CITY OF ALBUQUERQUE

January 2, 2020

Re: B&D Industries
9720 Bell Ave
Traffic Circulation Layout
Engineer's/Architect's Stamp 7-26-19 (L20D071)

### A1 SITE PLAN

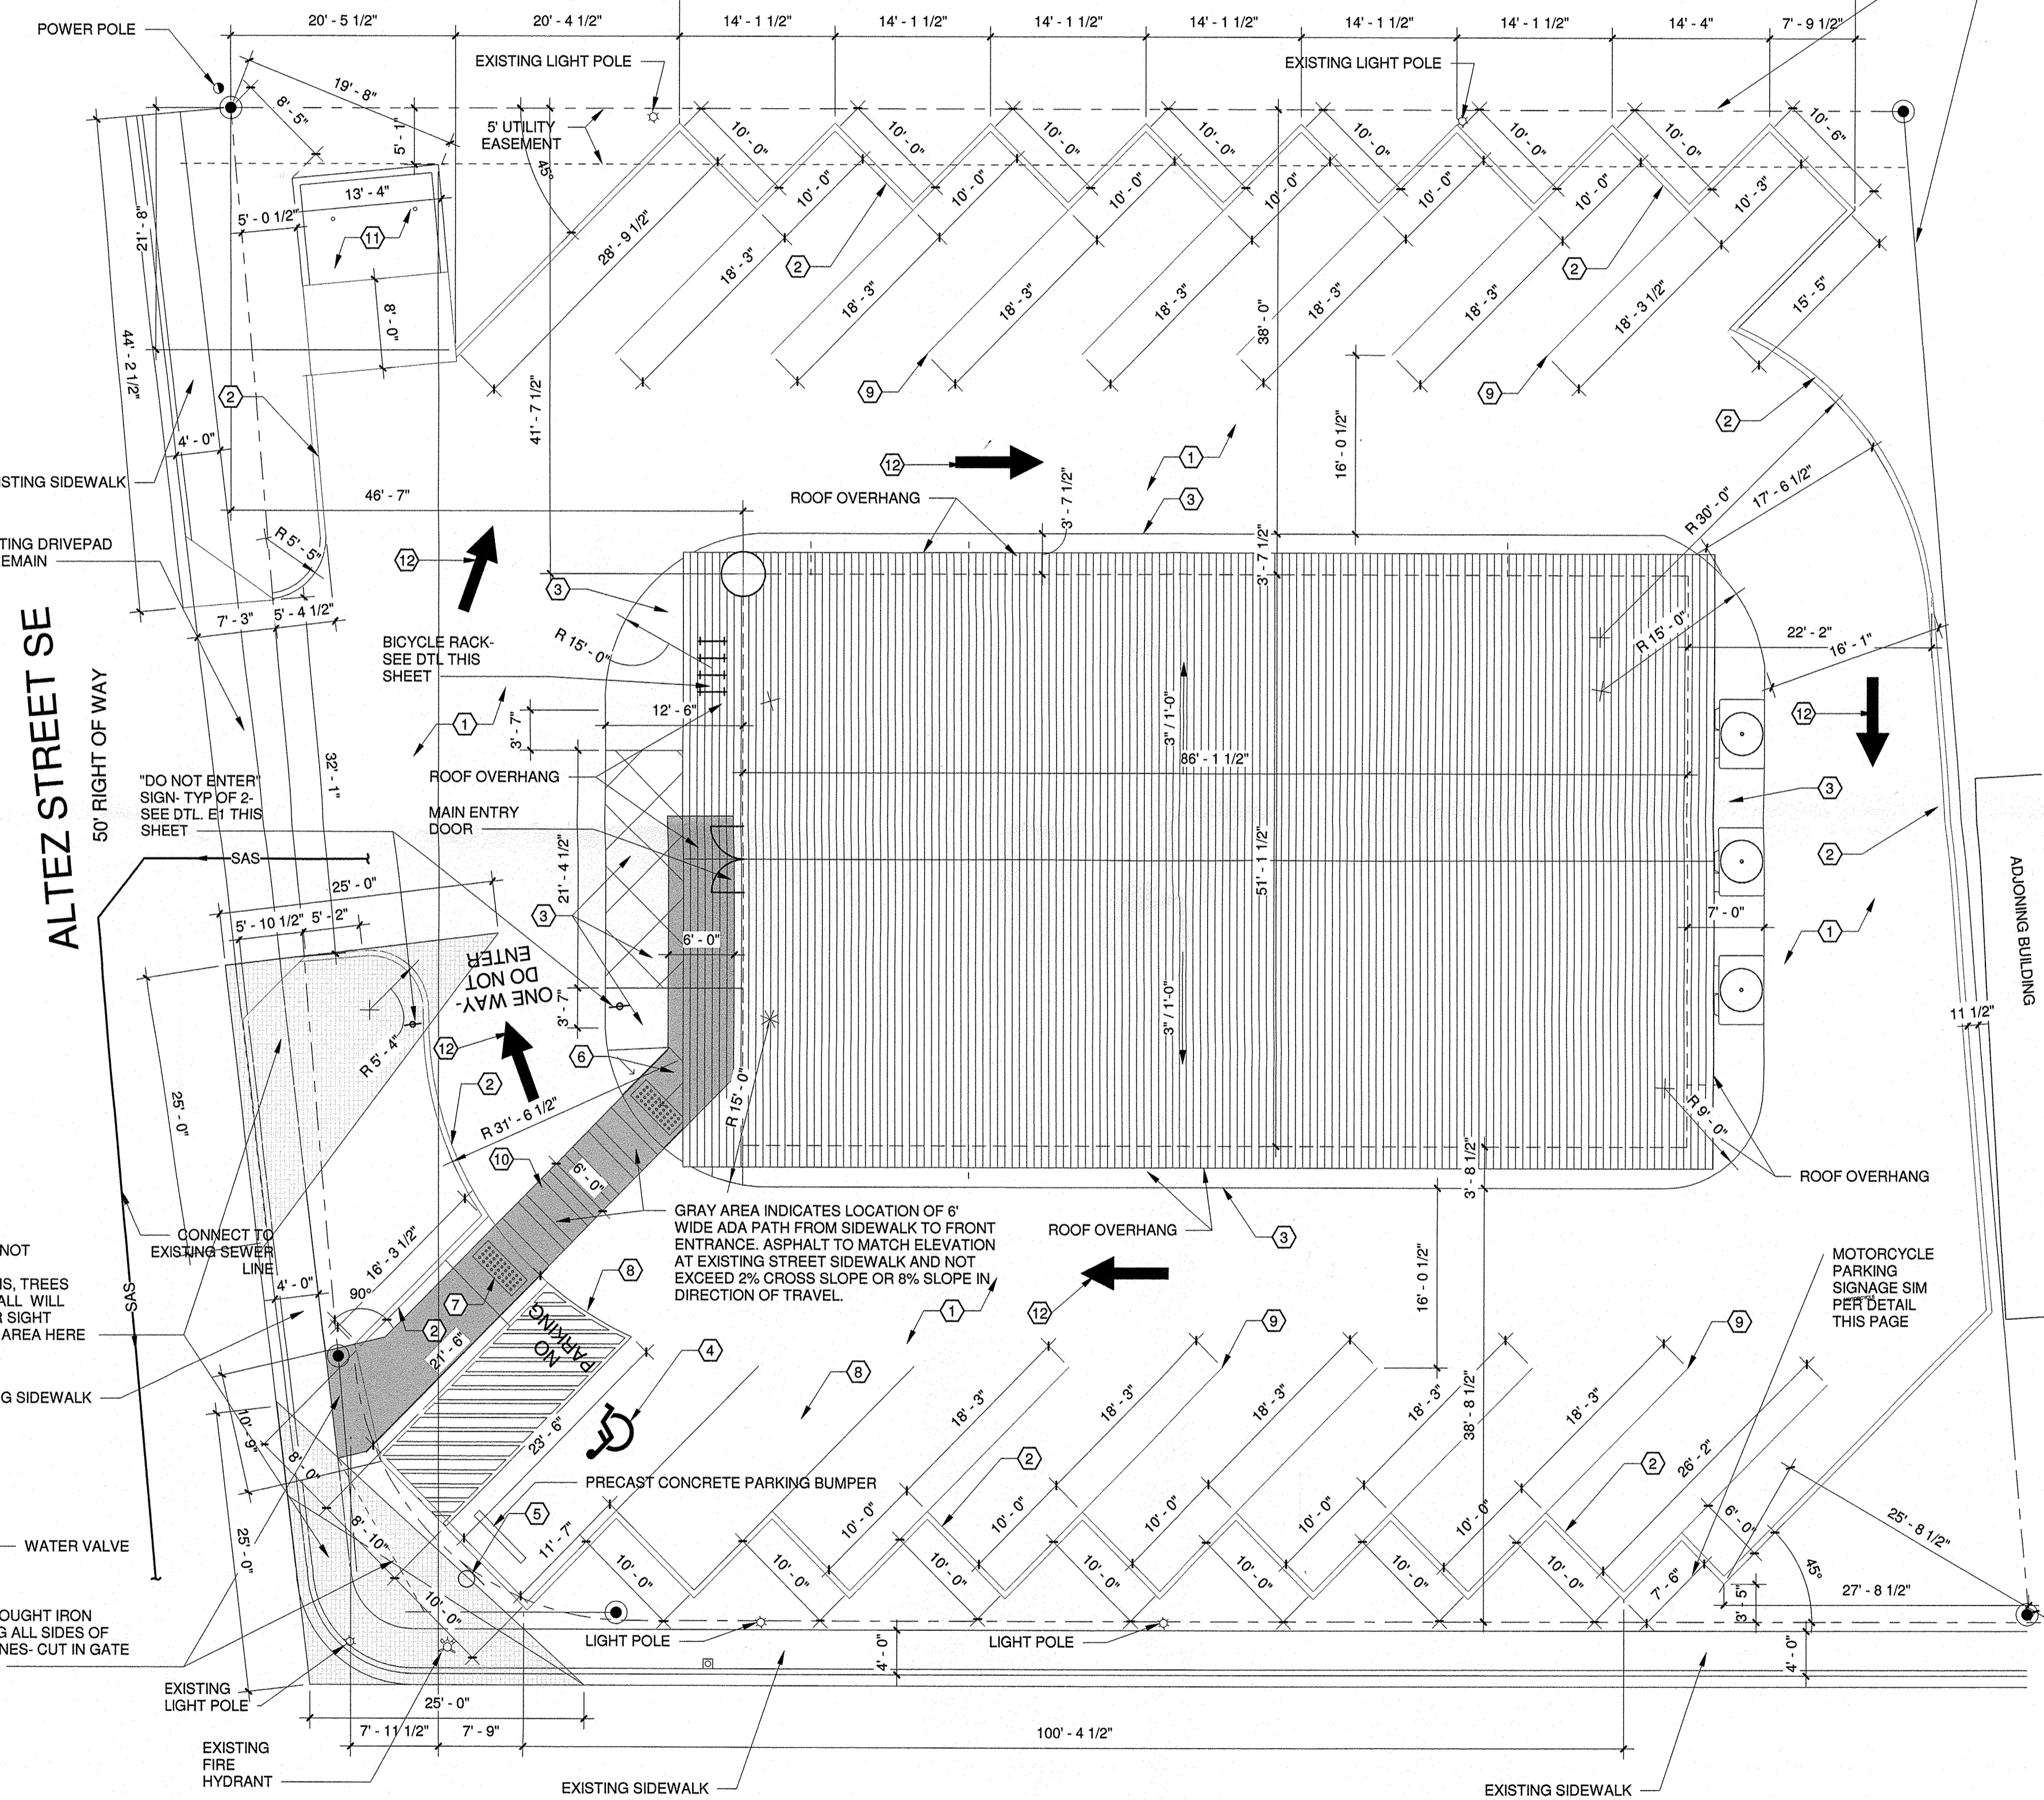
1. Please add bicycle parking per IDO. Show detail and add keynote.
2. Please indicate building door entrance.
3. Remove or identify section detail.
4. Indicate width of existing sidewalk.

5. Please add parking bumper at ADA stall.
6. Add keynote for directional arrows.
7. Please remove raised curb going through sidewalk.
8. Service vehicle and/or refuse vehicle maneuvering must be contained on-site; provide a copy of refuse approval.

9. Please add 2 **"Do Not Enter"** signs at point of egress. Add detail & keynote.
10. Please add clear site triangle at corner of Bell & Altez. Please add standard note used for clear site.

11. ADA path from public sidewalk to building entrance. Connecting asphalt to public sidewalk? Add note for asphalt to match existing sidewalk and please indicate max running slope of 8.0% and max cross slope 2.0%
